Our Ref: 7476/LRW/kc

Date 13th February 2024

Re: **Land rear of Chicane and Quintons, Ockham Road North, East Horsley, KT24 6PU** – Condition 8 Ref LLFA-GU-22-0445 Rev B

Further to the recent holding objection relating to the clearance of Condition 8 of the reserved matters planning approval for this site we enclose our response to queries along with supporting documentation.

DRAWING  
 Detention Basin  
 Sections

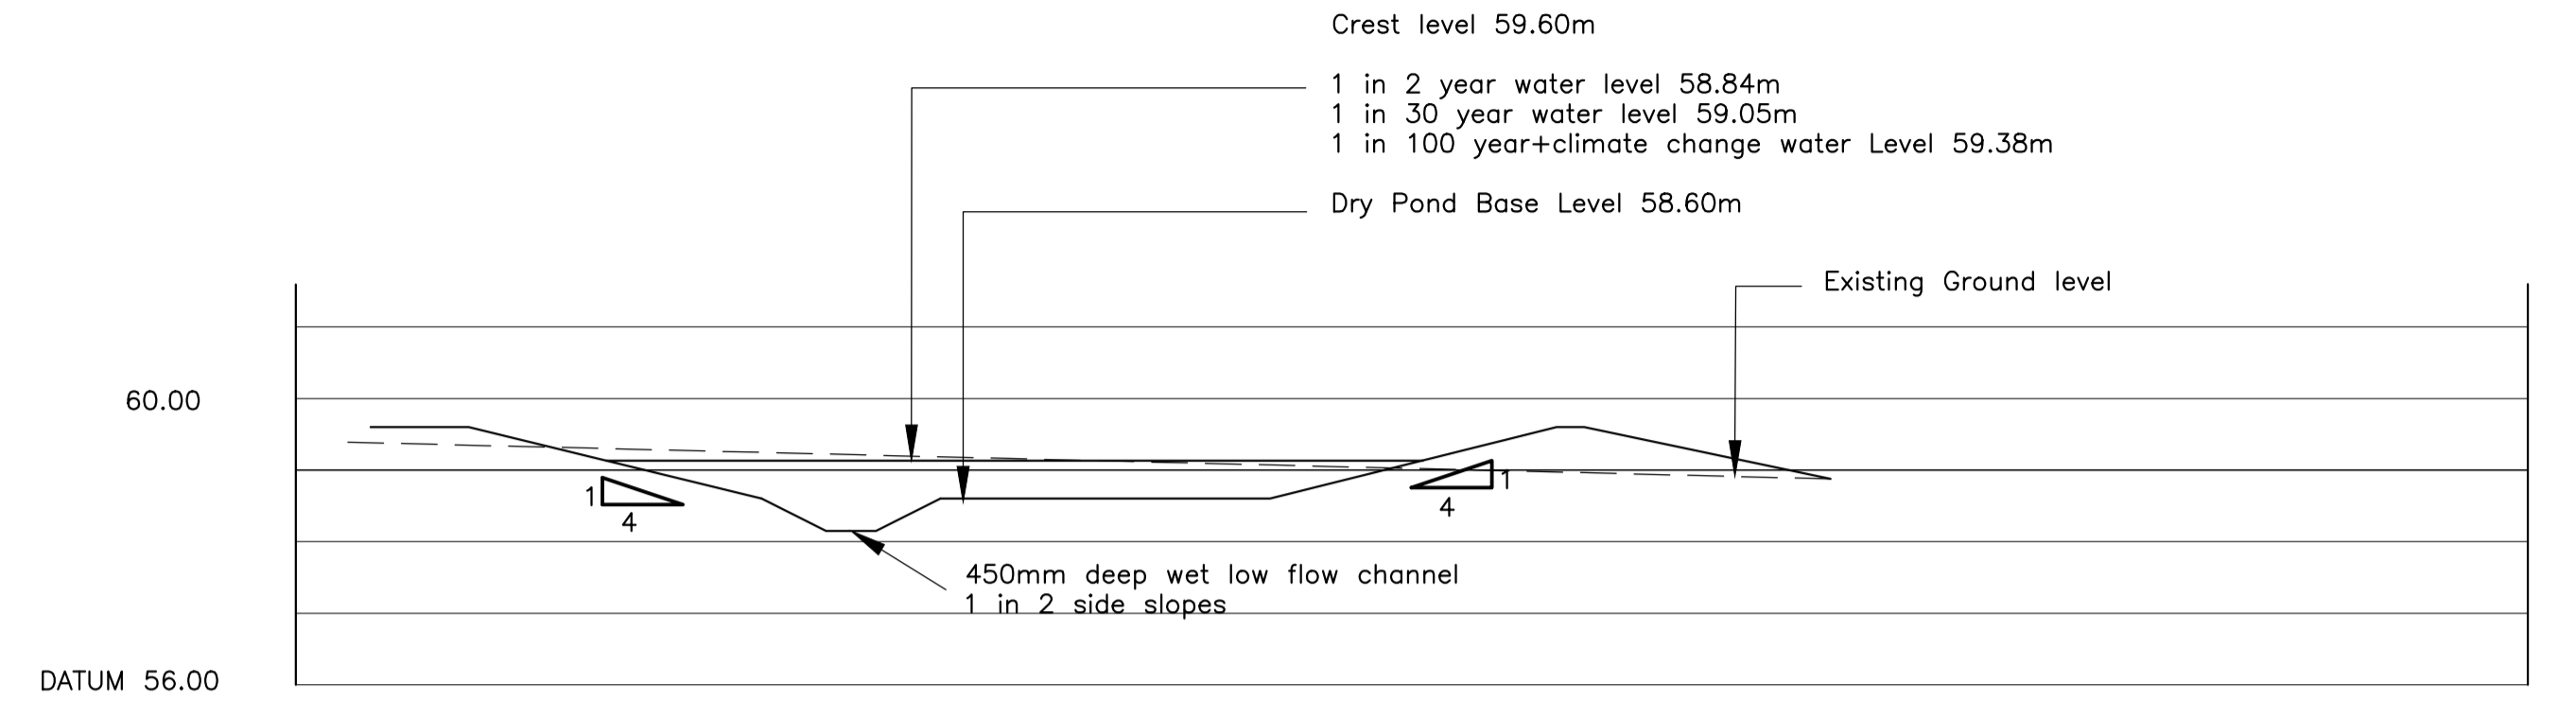
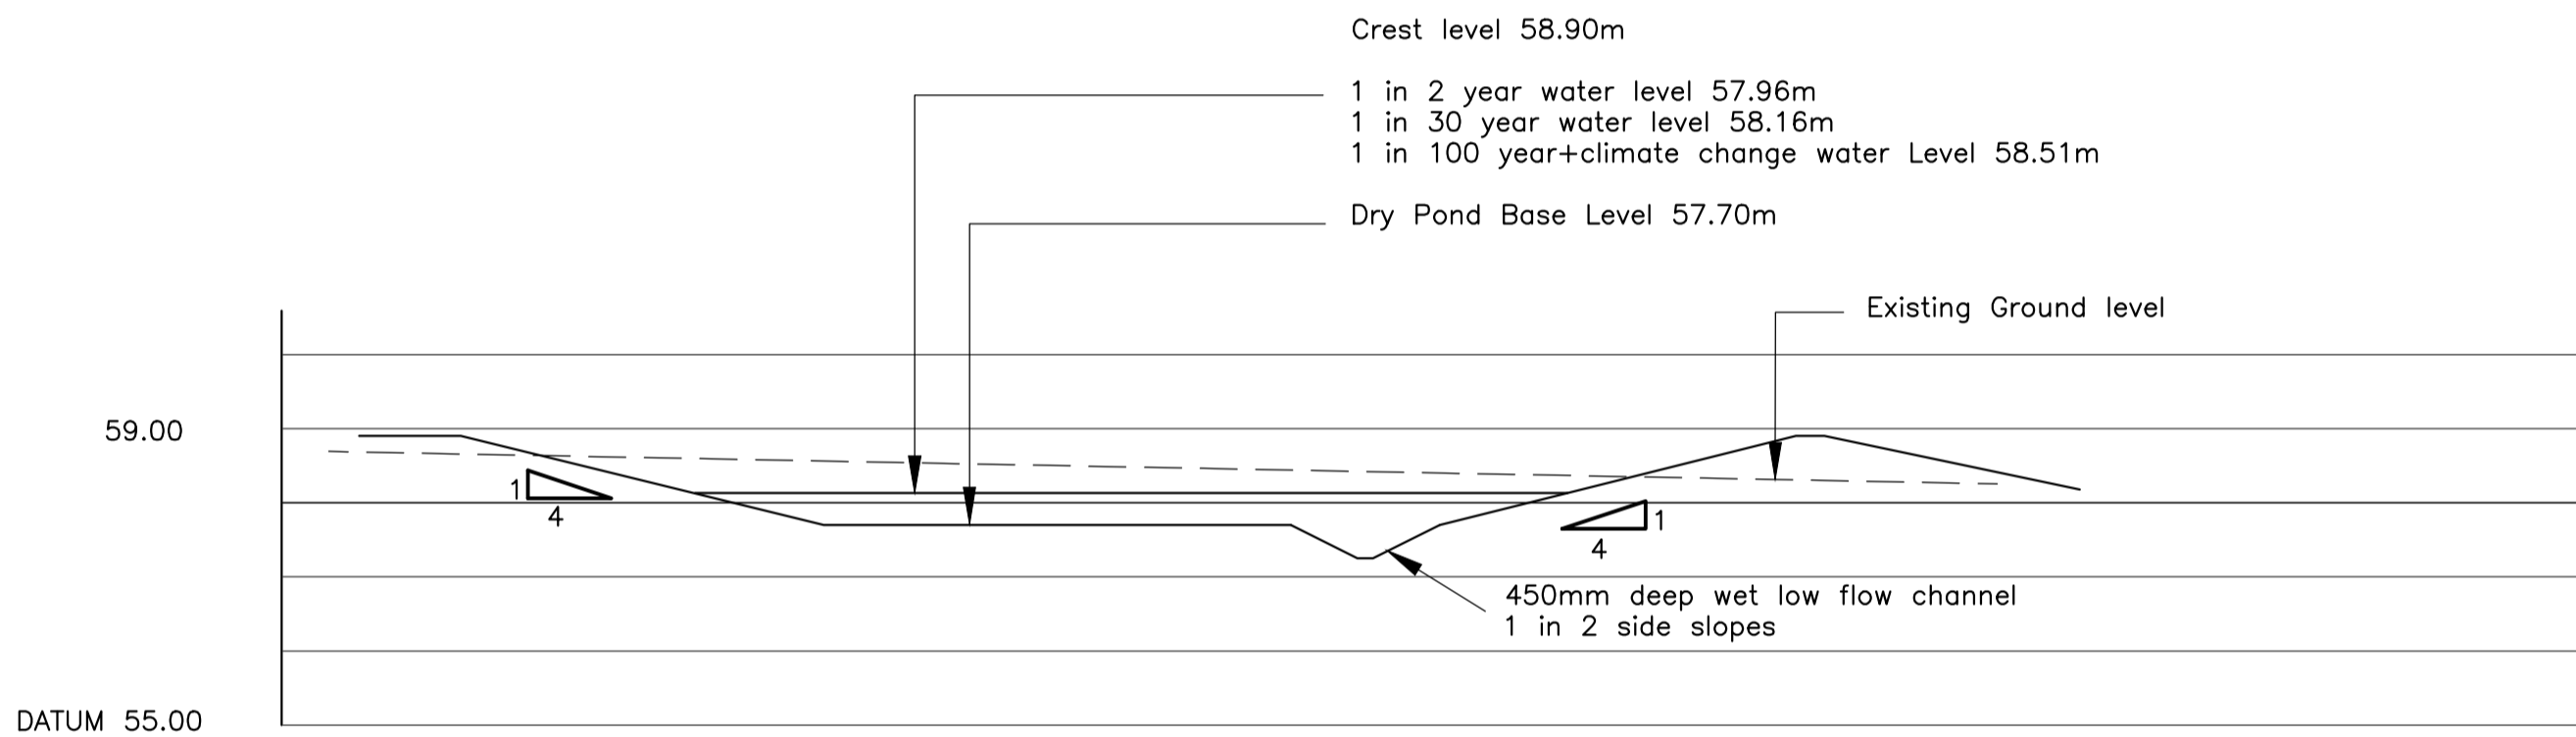
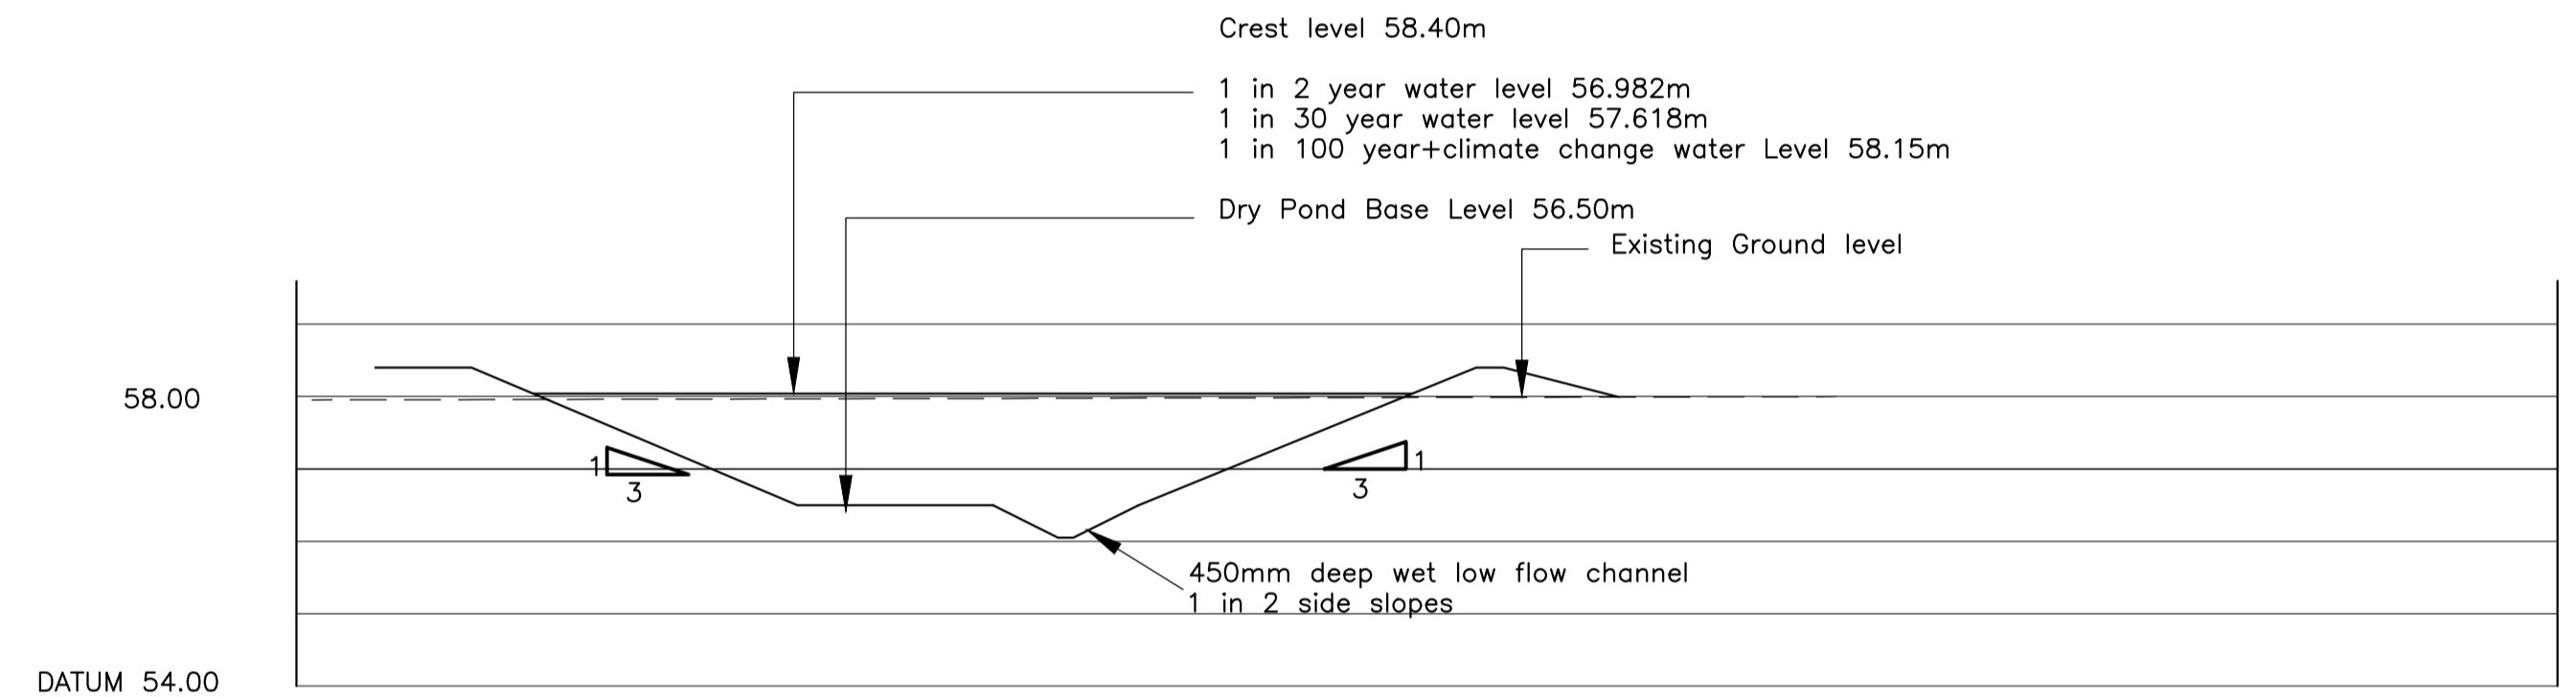
- iii. Is the base of the low flow channel just below the inlet out/inlet invert levels or the area below this is to remain wet? Sections do not show inlet/outlets and not clear from labelling.

- vi. Can surface water be retained above ground for the east development area rather than in the cellular storage tank?
- vii. Pond 4 is indicated on the section drawing as being a dry pond base. The engineering drawing has the base hatched as if it will have a permanent water level. If it is a dry basin both Pond 1 and Pond 4 should include sediment forebays and low flow channels to promote flow through the pond and improve the habitat. It is unclear if the ponds are proposed to be planted with grass or will provide wider ecological benefits.

iii. The low flow channels will sit below the inlet and outlets so will remain wet. Pond sections updated for clarity and reflect this.

vii. Pond 4 is to have a low flow channel and this has been updated on the engineering plans and sections. Ponds are to be planted with a wet wildflower seed mix in line with the landscape details submitted at planning.
